**WRITTEN SUMMARY OF ORAL SUBMISSIONS MADE AT HEARINGS ON 14 MAY 2019  
REGARDING THE APPLICATION BY SUFFOLK COUNTY COUNCIL FOR AN ORDER  
GRANTING DEVELOPMENT CONSENT FOR THE LAKE LOTHING THIRD CROSSING**

**PLANNING INSPECTORATE REFERENCE NUMBER TR010023**

**WRITTEN SUMMARY OF ORAL SUBMISSIONS MADE AT HEARINGS ON 14 MAY 2019  
ON BEHALF OF:**

**DATED: 24 MAY 2019**

**MAINLINE LONG SECTION
(WORK NOS. 1A, 1B, 1C, 1D & 1E
WORKS PLANS SHEET NOS. 1 & 2)**

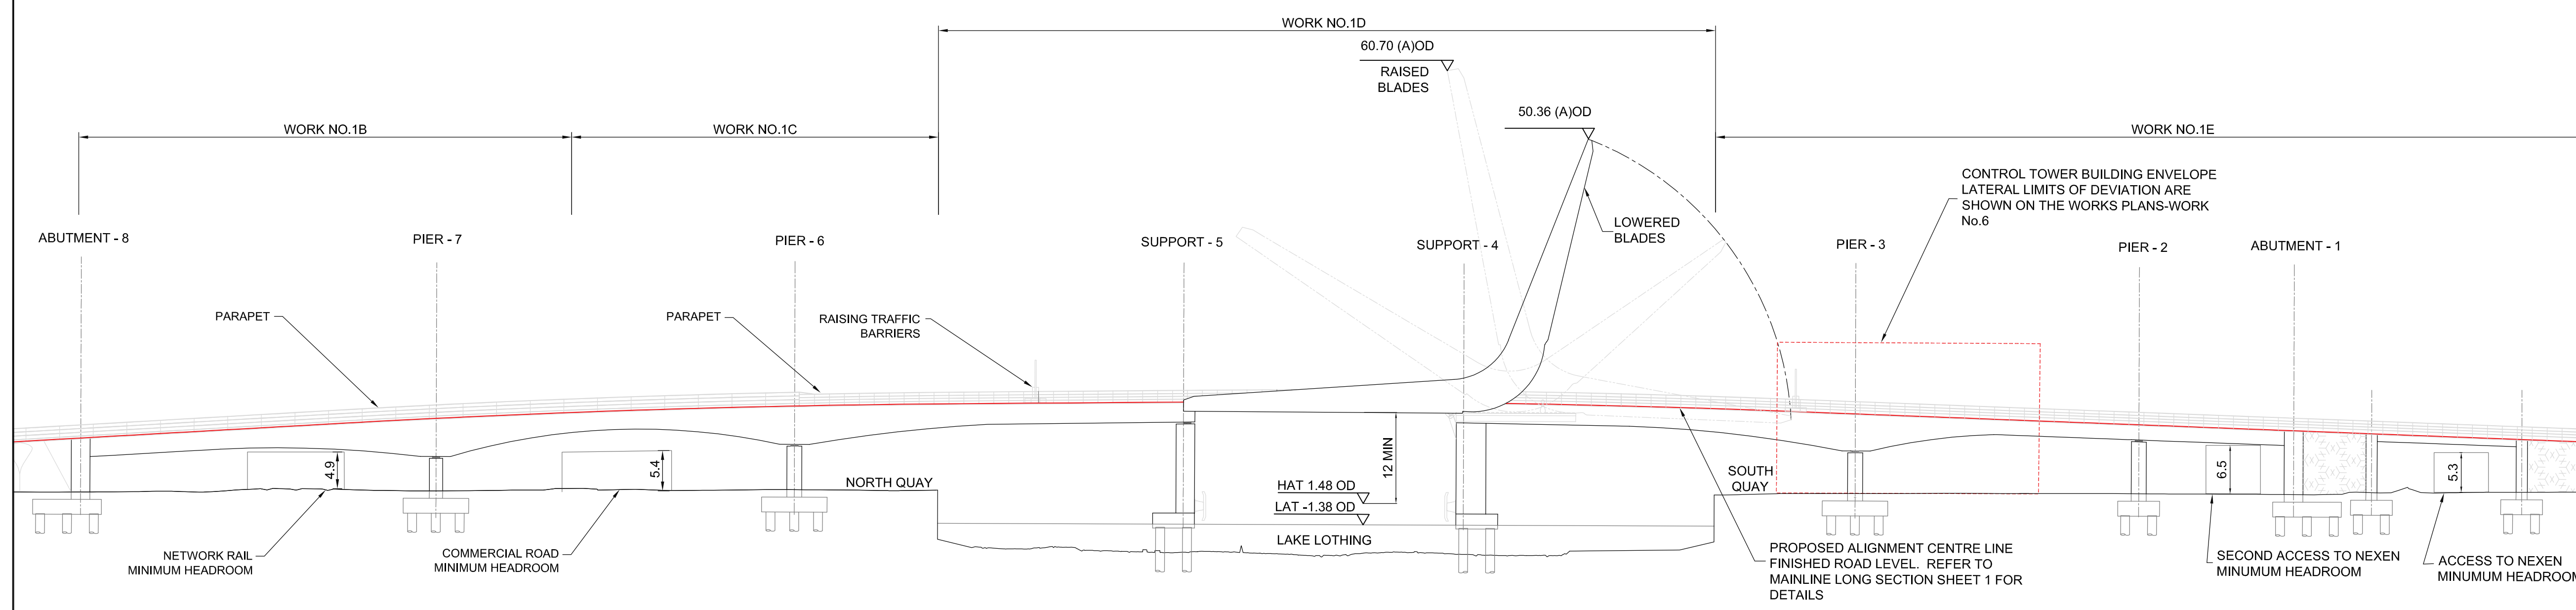
- 8 It was explained that since the first written representations on 8 January 2019 the Nexen Group have been seeking clarity in Article 5 of the draft DCO for the minimum underpass clearances to be set out in the draft DCO and for the current allowances for a 1.1m downward vertical limit of deviation for Work No. 1E to be removed. We expressed disappointment that this still had not been done.

- 9 At the hearing on 14 May 2019, the Applicant indicated that such a change was not necessary as the works were set out in engineering drawings. However, the “engineering section drawings and plans” are the plans to which the limits of deviation in Article 5 of the draft DCO relate. As a result, reference to such drawings does not provide the Nexen Group with any comfort.

- 11 The information supporting the recent scheme changes has now been submitted and is being reviewed by Nexen’s consultant team.
- 12 However, notwithstanding any comments that will arise from this review, the description of Work No. 1E and/or Work No. 6 in the draft DCO does need to be updated to reflect that it is proposed for a new public highway to form a new, more northerly (and additional) access into the Land as a result of NMC6. At present Work No. 6 in the draft DCO indicates that new highway would only provide a new access road and parking facilities for the new control tower building and electrical substation and plant room, not the Land. In addition, given the position of the proposed bridge above the more southerly underpass access into the Land, we query whether the latest Rights of Way & Access Plans (Sheet 2 of 2) is clear enough to show that this will be provided as public highway up to the boundary of the Land that shall remain in the ownership of the Nexen Group.
